Project No: ITB14679

Project Title: Land South of Ford Lane

Title: Stage 1 Road Safety Audit – GG119 Response Format

Ref: DS/ITB14679-006D

Drawing Title
Sections through public right of way footpath 357

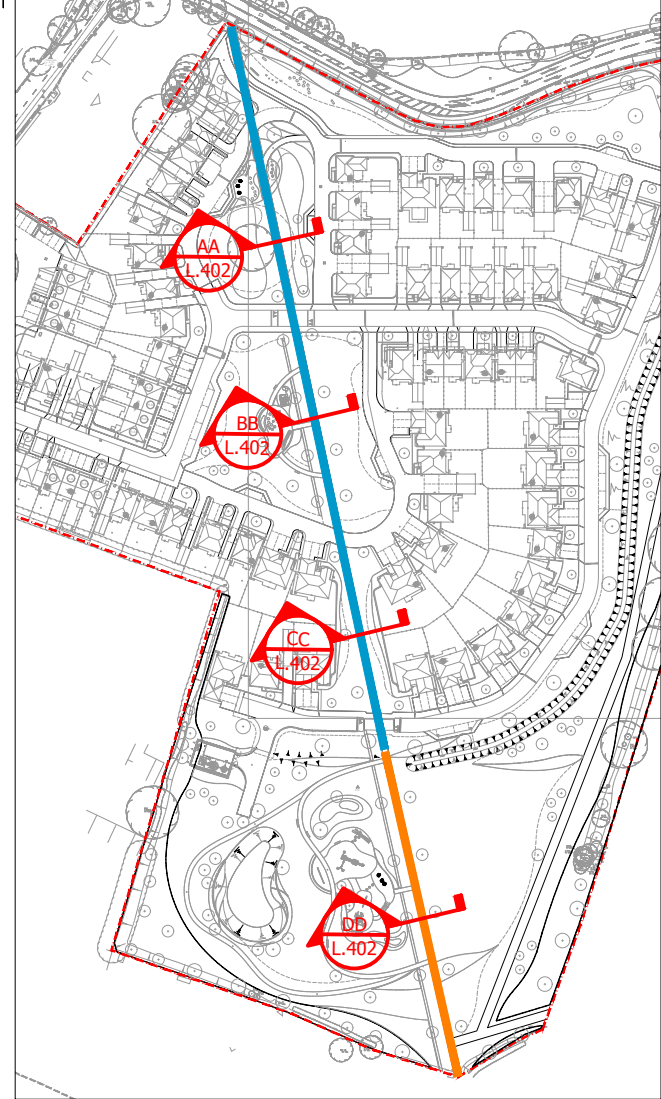
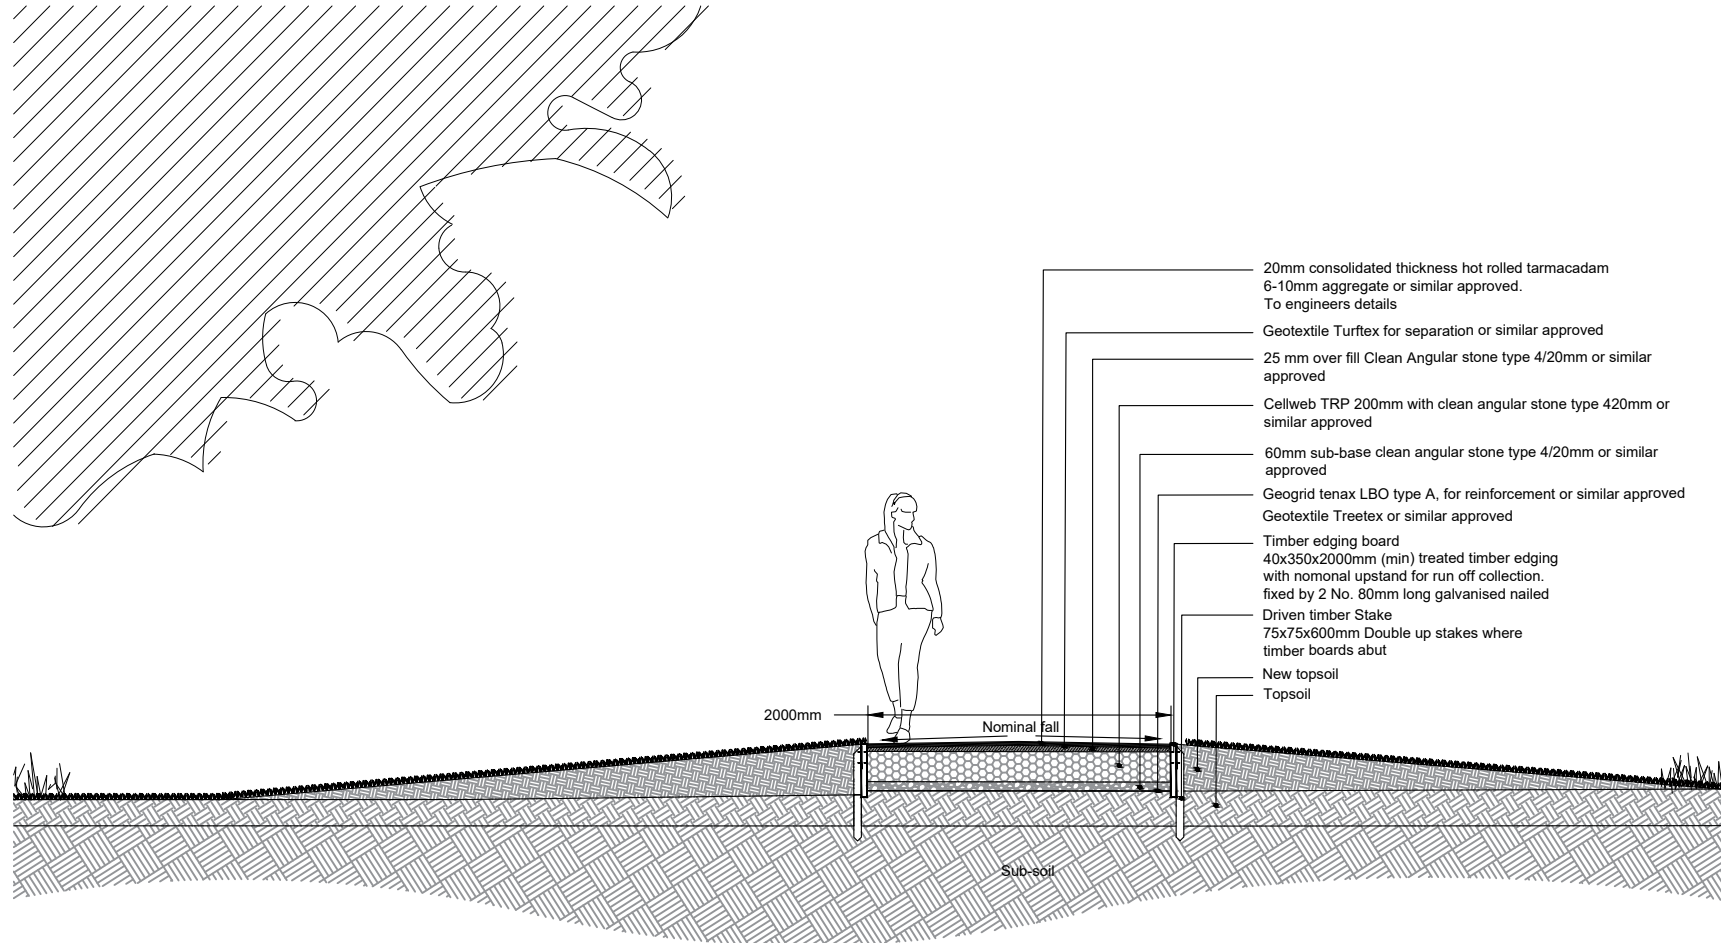
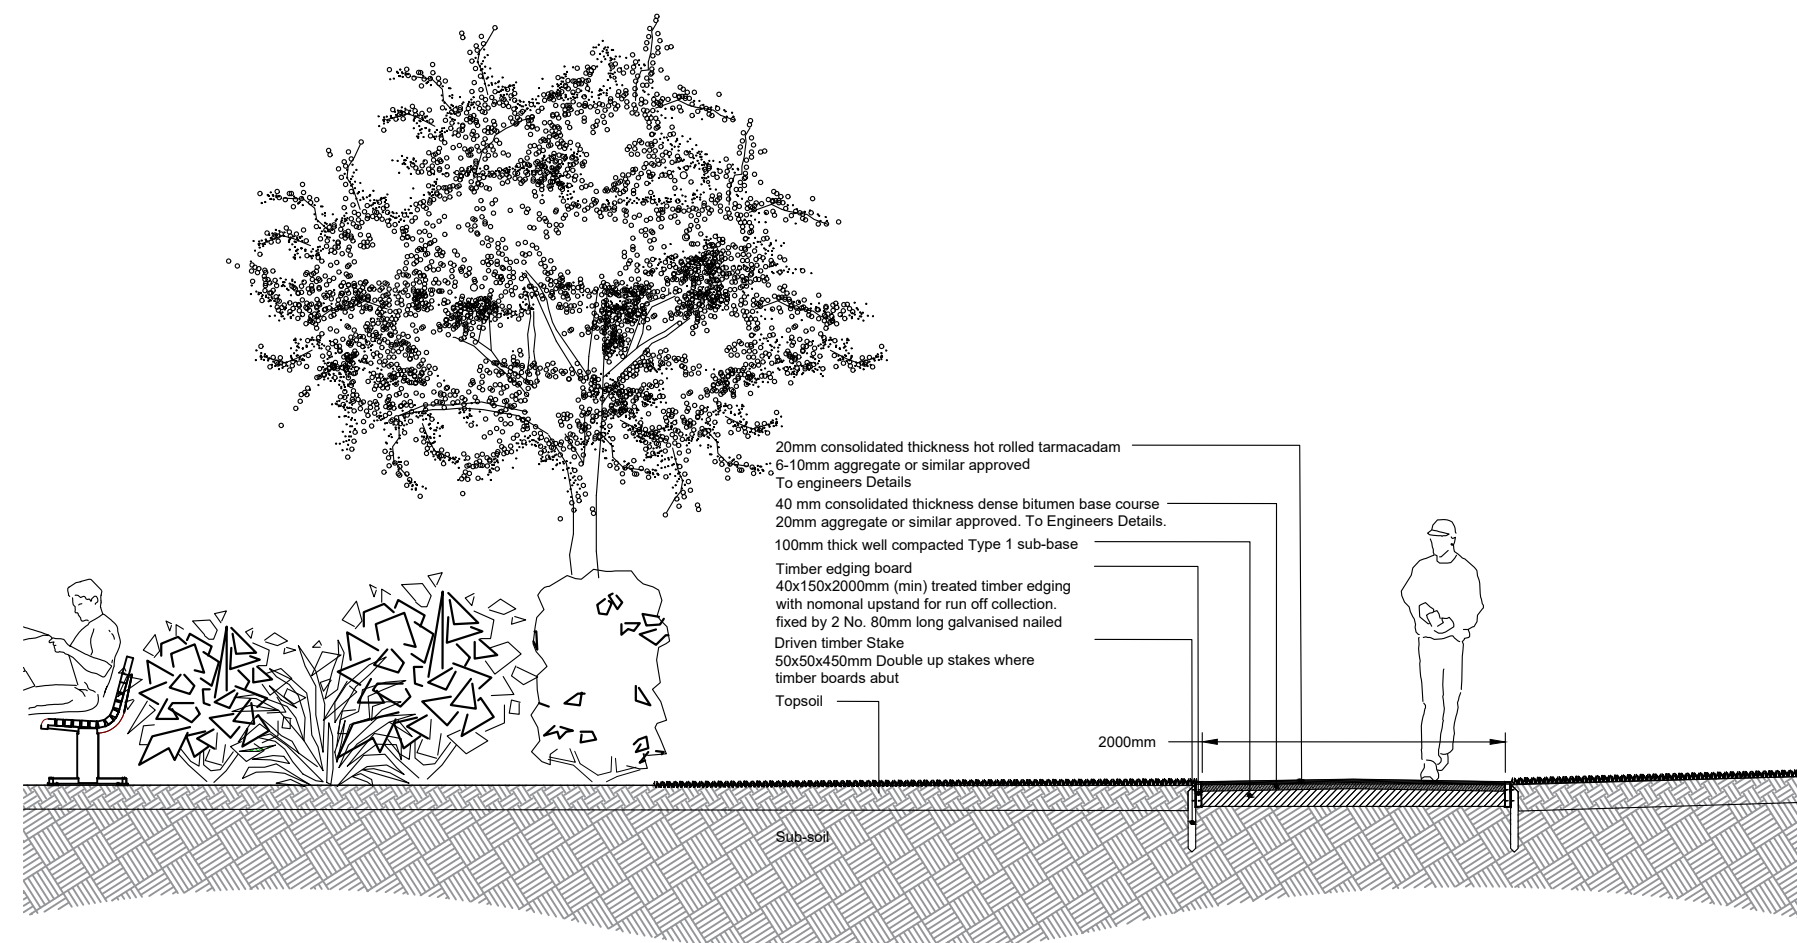
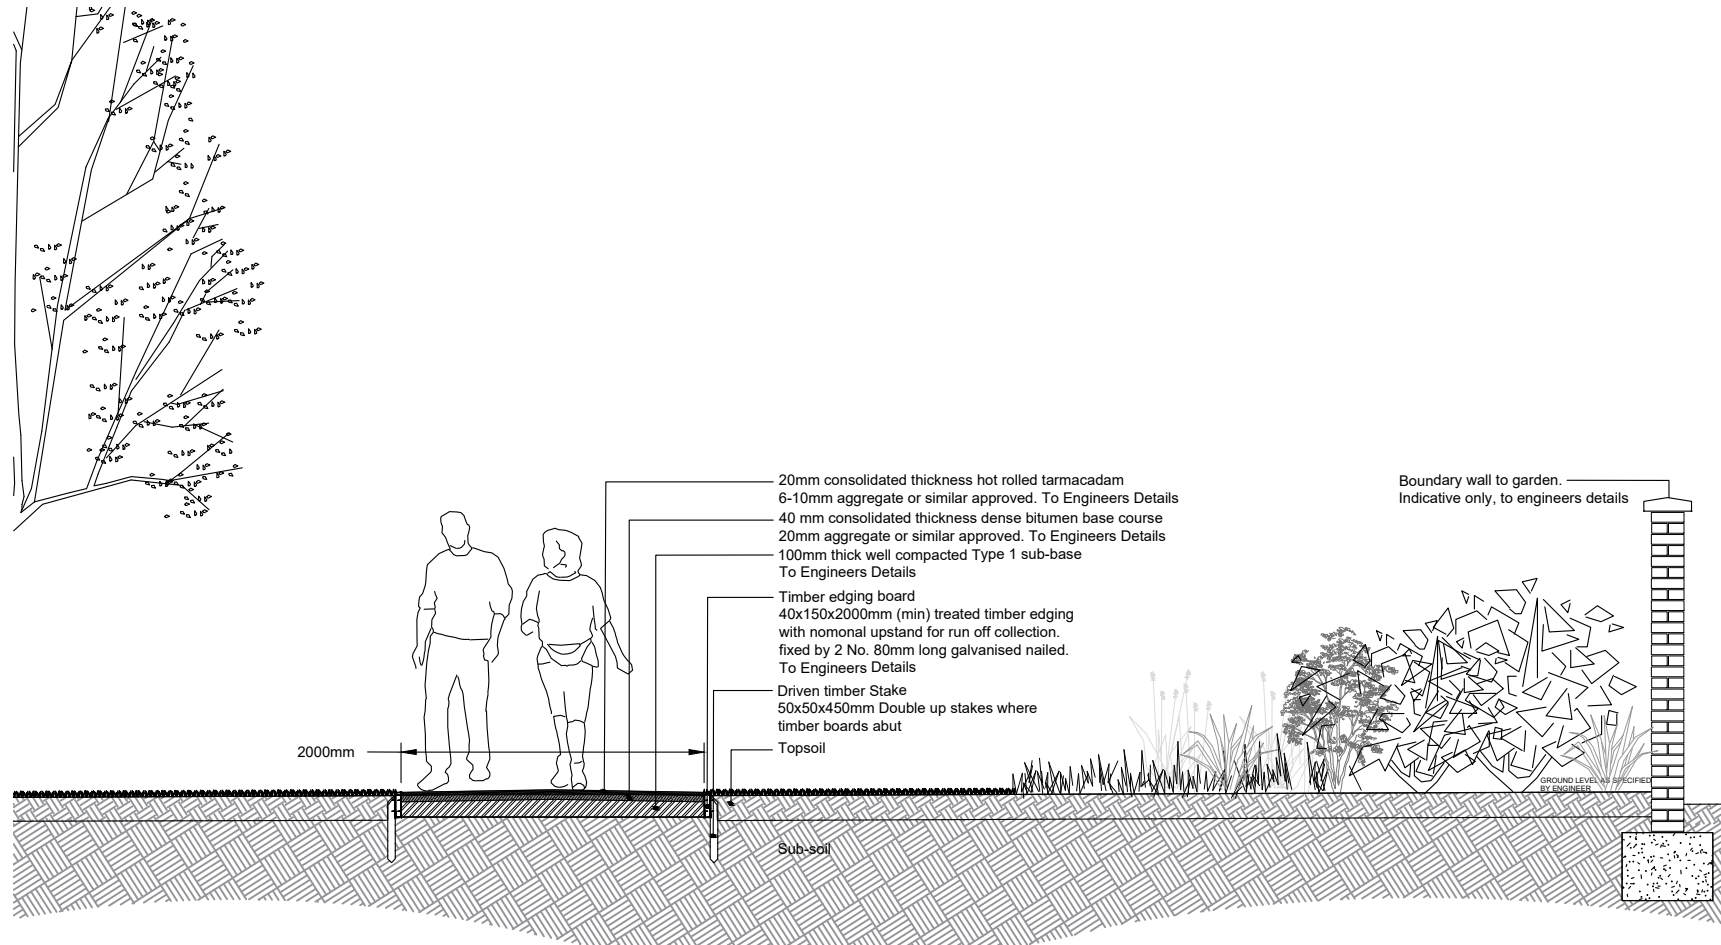
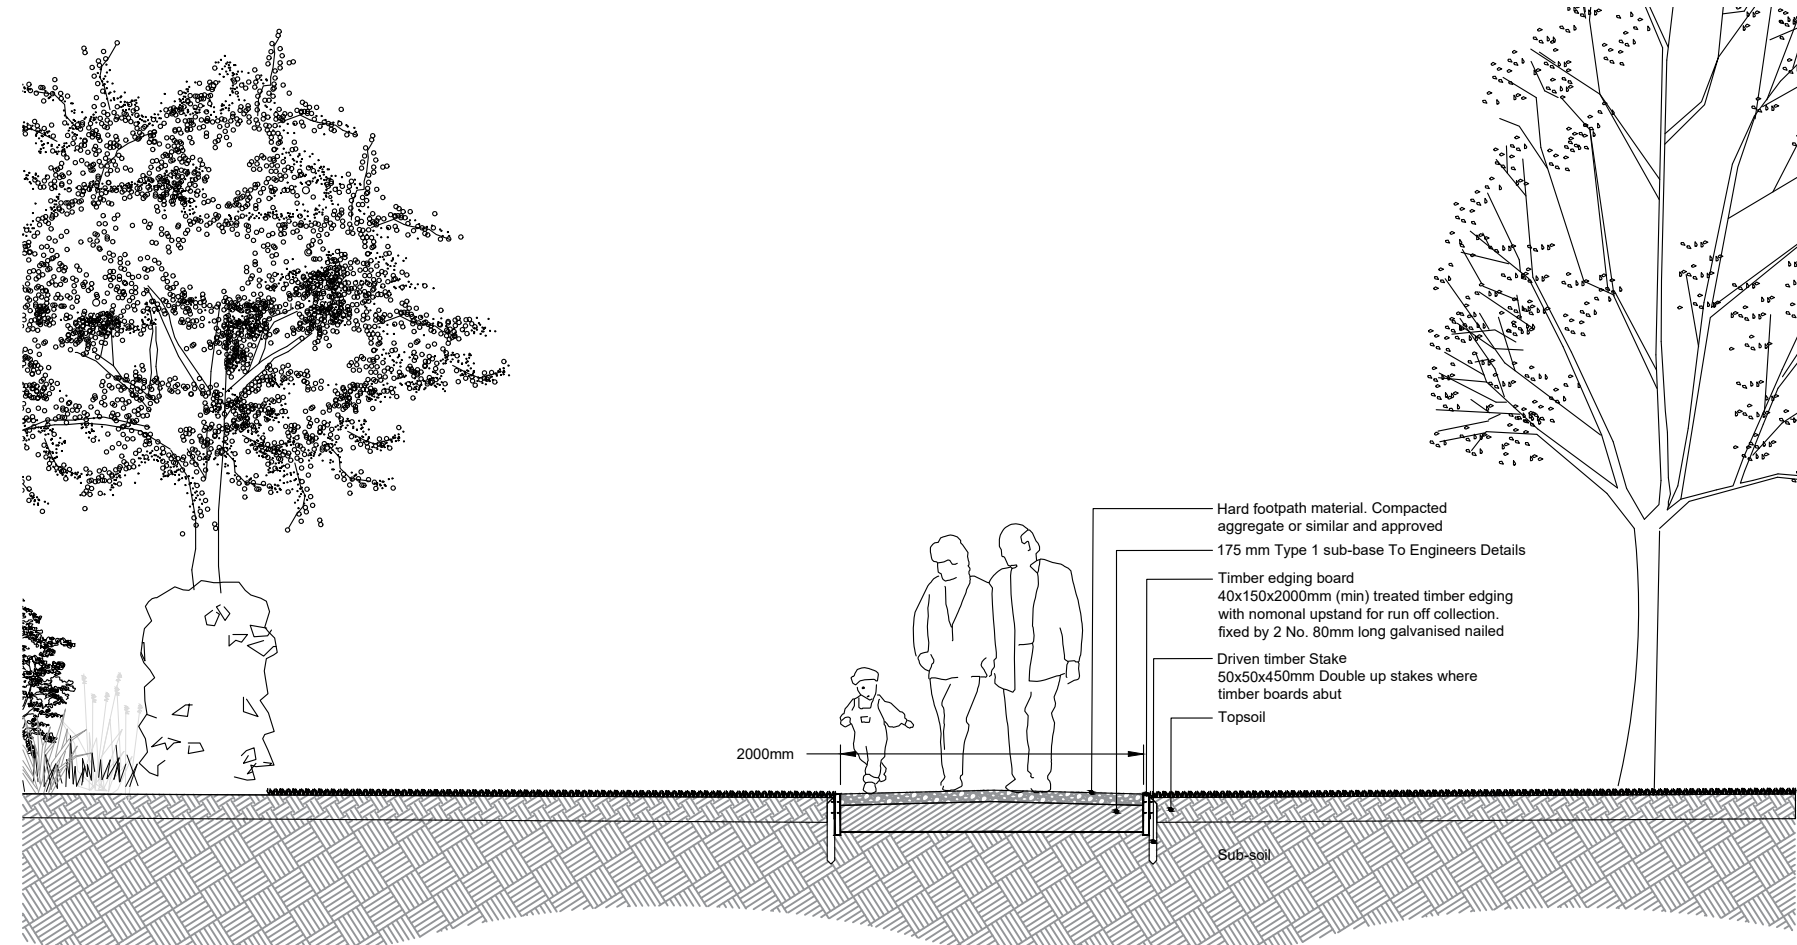
RSA Problem	RSA Recommendation	Design Organisation Response	Overseeing Organisation Response	Agreed RSA Action
2.1: Footpath 357 forms a public right of way that currently passes between the southeast and northwest extents of a field meeting footpaths 358 and 359 to southeast and Ford Lane to the northwest. The field is set above the level of the Ford Lane carriageway with access gained via a set of 6 uneven concrete slab steps with a wooden handrail, up the grass embankment. The Audit Brief that has been supplied to provide sufficient information to undertake this Stage 1/2 Road Safety Audit, states that the connections between the site and existing rights of way which are outside the redline boundary, are outside the scope of the Audit and that the current proposals are to provide footpaths within the application site. However, it is understood that there are aspirations to upgrade footpath 357 to a footway cycleway. Whilst the existing connection between the footpath and Ford Lane allows pedestrian to walk up steps that are currently substandard and result in a pedestrian stepping straight onto the carriageway, the use of the connection by cyclists would result in the requirement for a bicycle to be transported up / down steps and could lead to cyclist falling and a personal injury or falling into the Ford Lane carriageway into the path of a vehicle resulting in a vehicle cyclist collision.	It is recommended that the northern most section of footpath 357 is reduced to 2 metres and measures are provided to deter use by cyclists with landscaping / planting provided either side of the staggered barriers to ensure that cyclists cannot bypass the measures.	Accepted – the width of the footway has been narrowed to 2m and landscaping features have been identified on either side of the path/barrier to prevent by-passing of the infrastructure. The revised design is presented in drawing ITB14679-GA-002 Rev G. 31/3 – as part of the now approved S278 highway works, the steps are to be replaced by a ramped/slope arrangement. As the steps will no longer present a falling hazard to cyclists, the route has been reinstated at a 3m width in the design before transitioning to the approved S278 design. Staggered barriers are to be retained with landscaping measures to prevent by-passing.	29/3 – it is my understanding that the steps currently providing pedestrian access to Ford Lane at the northern end of Public Footpath 357 and referred to in the Safety Audit are to be removed and replaced by a ramp as part of the S278 works for Ford Lane. Please check and confirm is this is correct and refer to the Audit Team for any further comments.	Reinstate 3m footway and provide staggered barriers with measures to prevent by-passing as identified in Drawing ITB14679-GA-002 Rev G.

RSA Problem	RSA Recommendation	Design Organisation Response	Overseeing Organisation Response	Agreed RSA Action
2.2 The existing footpath 357 that passes through a field to the east of North End Road and south of Ford Lane in an unmade and narrow route that is uneven in places. The proposals subject to this Stage 1/2 Road Safety Audit include the widening of the existing footpaths to 3 metres and the reconstruction with a 225mm base course below 75mm of dust and 100mm of limestone type 1 topped with 25mm of limestone dust which will provide an adequate surface that is cambered to ensure surface water drains to the soft verges either side that are detailed on the landscaping plans associated with the approved application Y/112/20/DOC. The current proposals illustrated on dwg ITB16479-GA-002 revision B included with the Audit Brief, identifies that staggered barriers are to be provided adjacent to all locations where the public right of way crosses the on-site roads. The scheme drawing also identifies that raised tables or shared surface areas are to be provided where the footpath crosses the on-site roads and the landscaping plans indicate that the crossings are to be fairly open with no high-level planting provided in close proximity. Whilst staggered barriers assist in slowing users to ensure that they proceed with caution, users tend to bypass the measures if a route is available. It is therefore likely that users of the public right of way, will bypass the staggered barriers on the adjacent soft verge which is likely to become uneven as a result of use particularly during inclement conditions. An uneven surface could give rise to trips, falls and personal injury.	It is recommended that the staggered barriers are replaced with bollards that include reflective features to reduce the likelihood of users bypassing the surfaced route and crossing at a location away from the dropped kerb crossing points that benefit from tactile paving.	Accepted – the staggered barriers have been removed from the internal aspect of the layout and replaced with bollards. The bollards with the fitted with reflective material, and also incorporate way-finding for the Public Right of Way. The amendments are presented in drawing ITB14679-GA-002 Rev G.	Accepted.	Staggered barriers/bollards to be implemented in accordance with Drawing ITB14670-GA-002 Rev G. Refer to Additional Comment 20/04/21 – Option 1 for further commentary at North End Road.
